September 17, 2009

Ms. Anna Nelson
Kittitas County Community Development Services
411 N. Ruby, Suite 2
Ellensburg, WA 98926

Re: Application of Teanaway Solar Reserve LLC
For Conditional Use Permit (CUP)
Teanaway Solar Reserve (CU-09-00005)

**FIGURE 2**  
**Proposed Site Layout**  
 Vegetation Management Plan  
 Teanaway Solar Reserve  
 Kittitas County, Washington

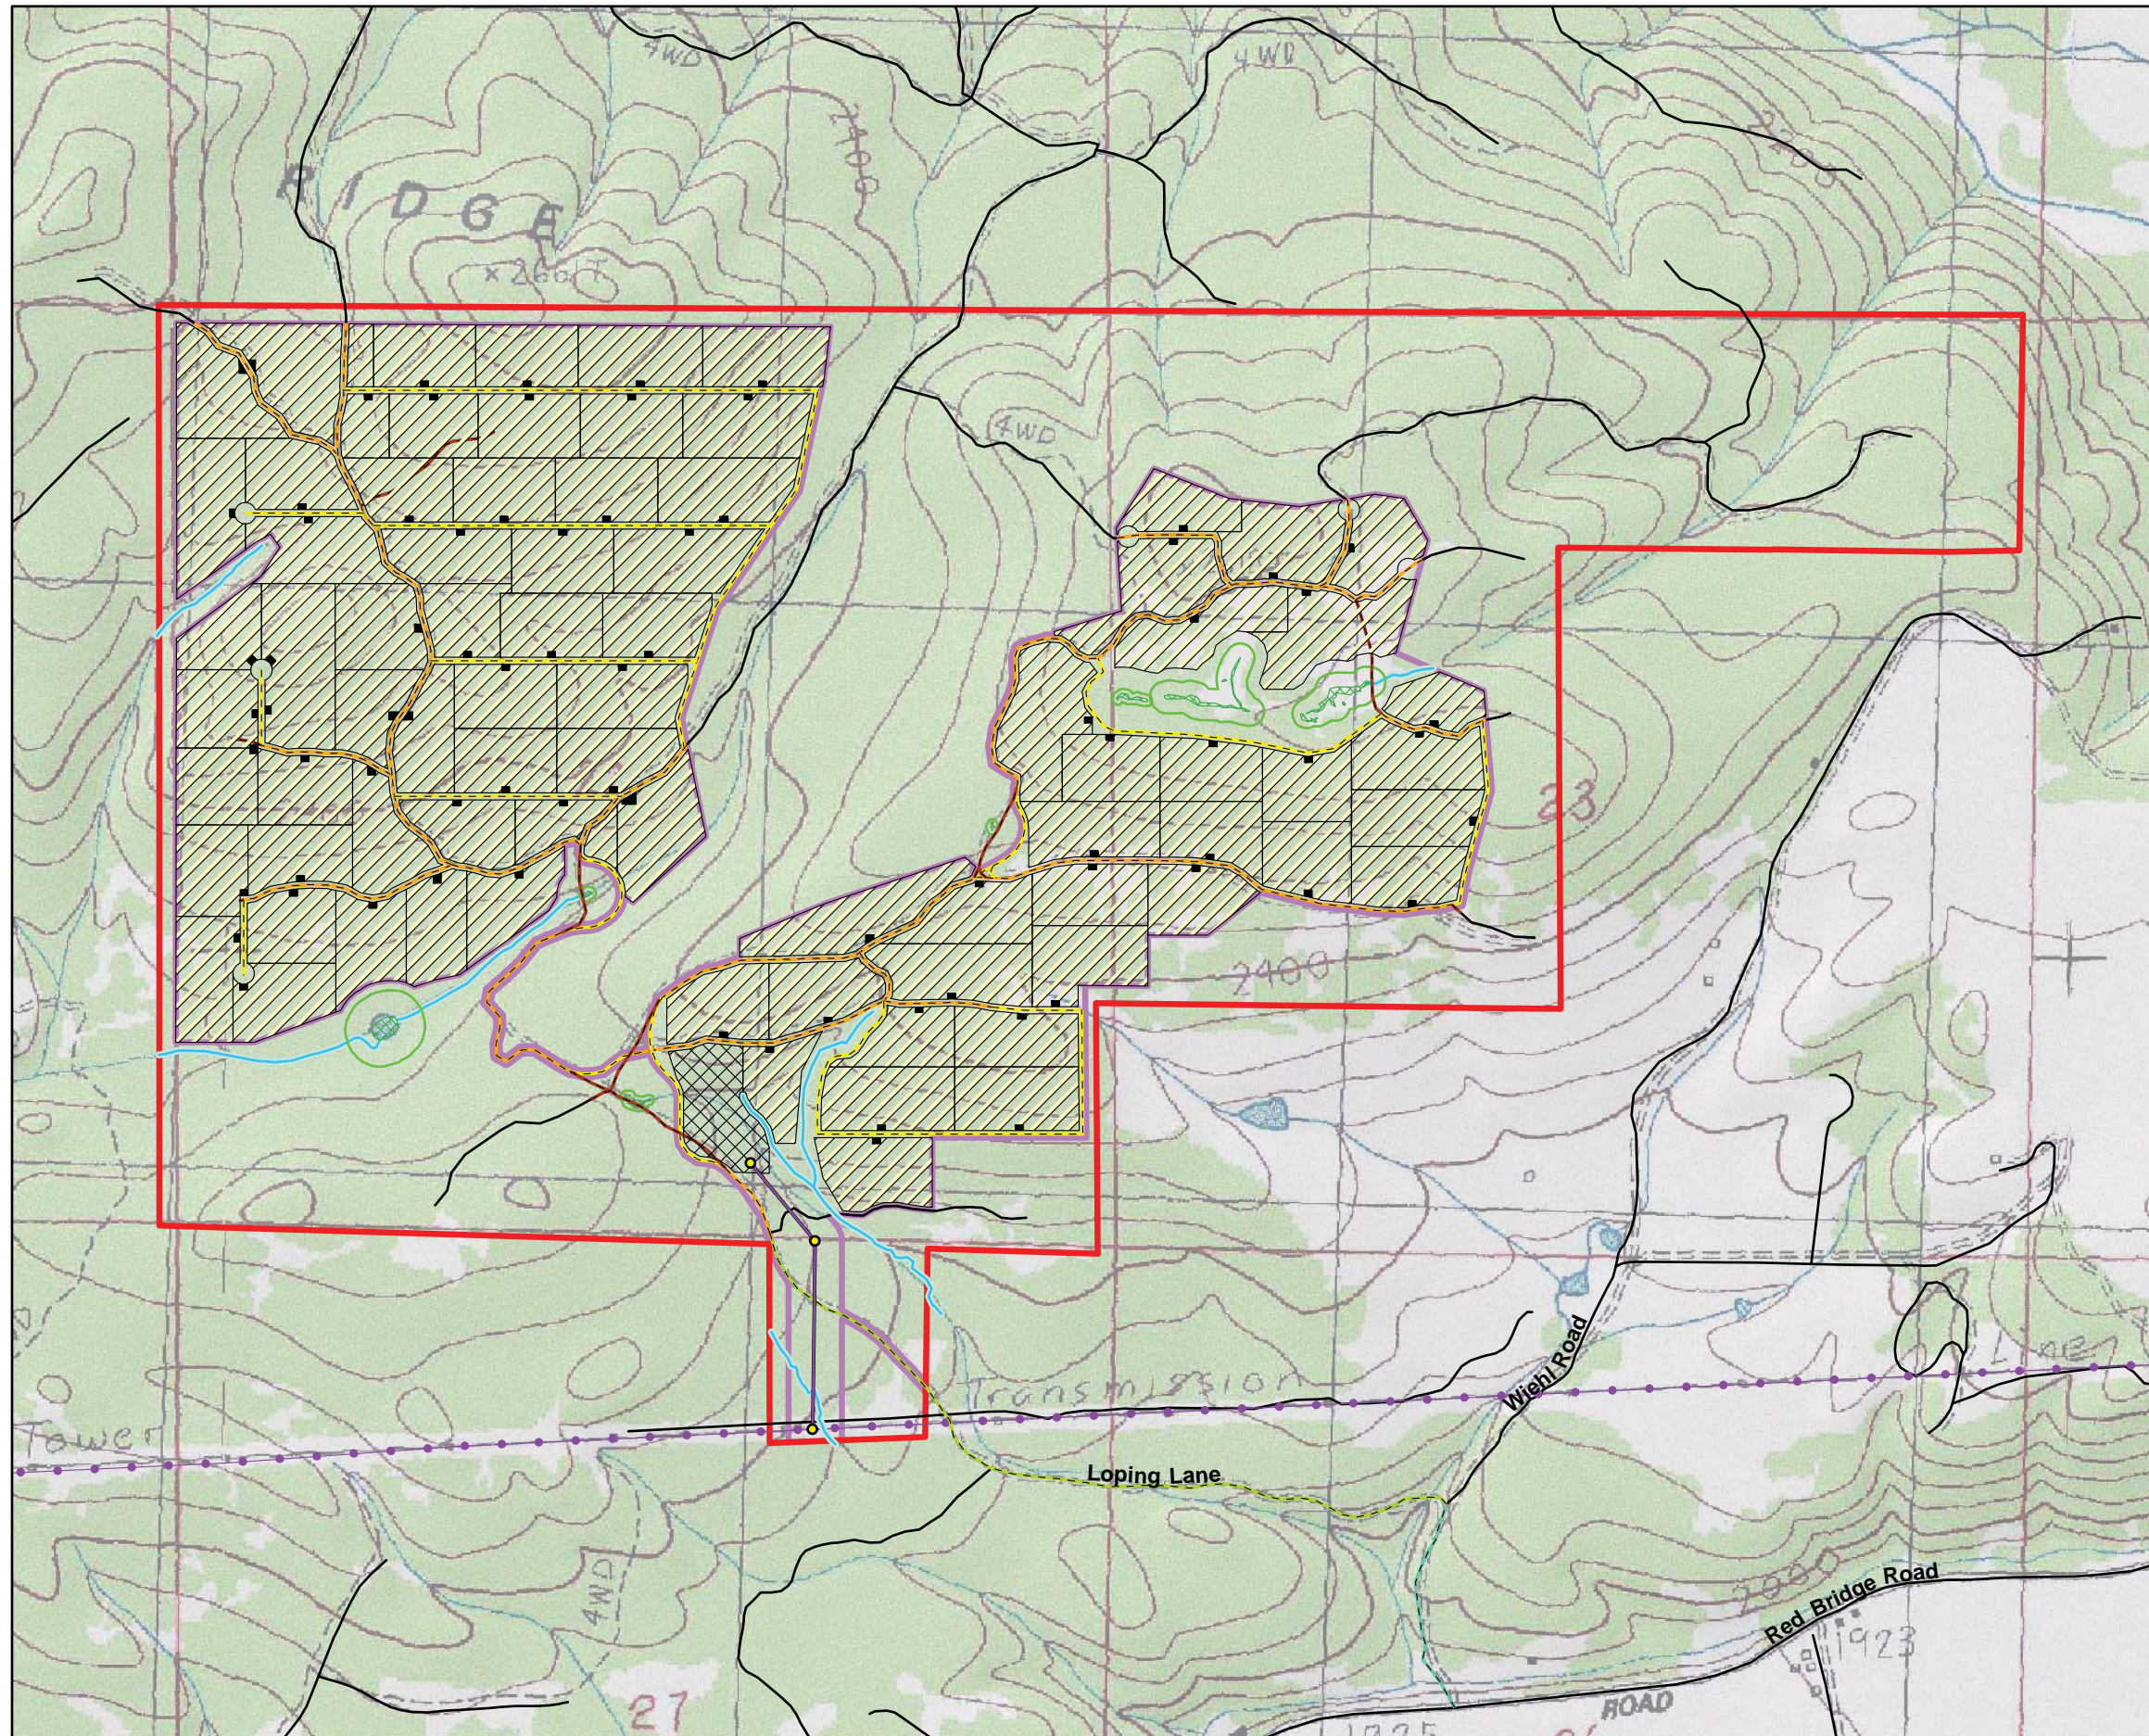
In an attempt to be more specific about elk movements, regardless of the season, I have marked on attachment B (Applicant's Figure 5 Conceptual Site Layout) our general observations of the main elk movements, both daily and seasonally, which cross our property on to the east/northeast corner of the solar site. Although they cross at virtually all points, in a general sense they move up Cle Elum ridge to the upper meadows and also onto the north facing slopes above the Teanaway River. The deer cross on to the site in more random fashion.

As attachment B shows, Applicant's "conceptual" design shows about a 500 foot setback along its eastern boundary and very little development proposed in the northeast part of their site. This fact is probably due primarily to the north facing nature of the land as it slopes down toward the Teanaway River in much of this area. Regardless of the reason, if the CUP is approved, this setback along its boundary and the northeast part of the site should be left in its natural state and set aside as wildlife corridor and wildlife open space to protect the elk, deer and predator populations. We are not very familiar with the western portions of Applicant's site and therefore do not comment on it specifically, other than to note that it is all part of the same ecosystem, and it also should be studied as part of an overall EIS.

J. Proposed Setbacks. Applicant has only provided a "conceptual" view of the actual solar panel placement on its site and the related project setbacks from its property lines. This conceptual representation is included as Attachment B. This attachment shows about a 500 foot setback along our joint property line. Because this is only a conceptual representation, we have no way to determine if this setback is adequate to mitigate the impacts to our property.

We believe that a larger setback will not only help to shield our property from some of the negative effects of the project but also help to provide a buffer and corridor for deer, elk and other wildlife to move up the slope to the north facing areas of the site, where Applicant shows no construction and where we have observed the most deer and elk activity. These setbacks should be made a condition of any permit and not something to be applied in Applicant's discretion.

Applicant also shows only a minimum setback of 100 feet along portions of its southern boundary which pass close to a number of substantial homes. Although we assume that this issue will be addressed by those neighbors, this minimum setback seems unreasonable in light of its direct visual impact.
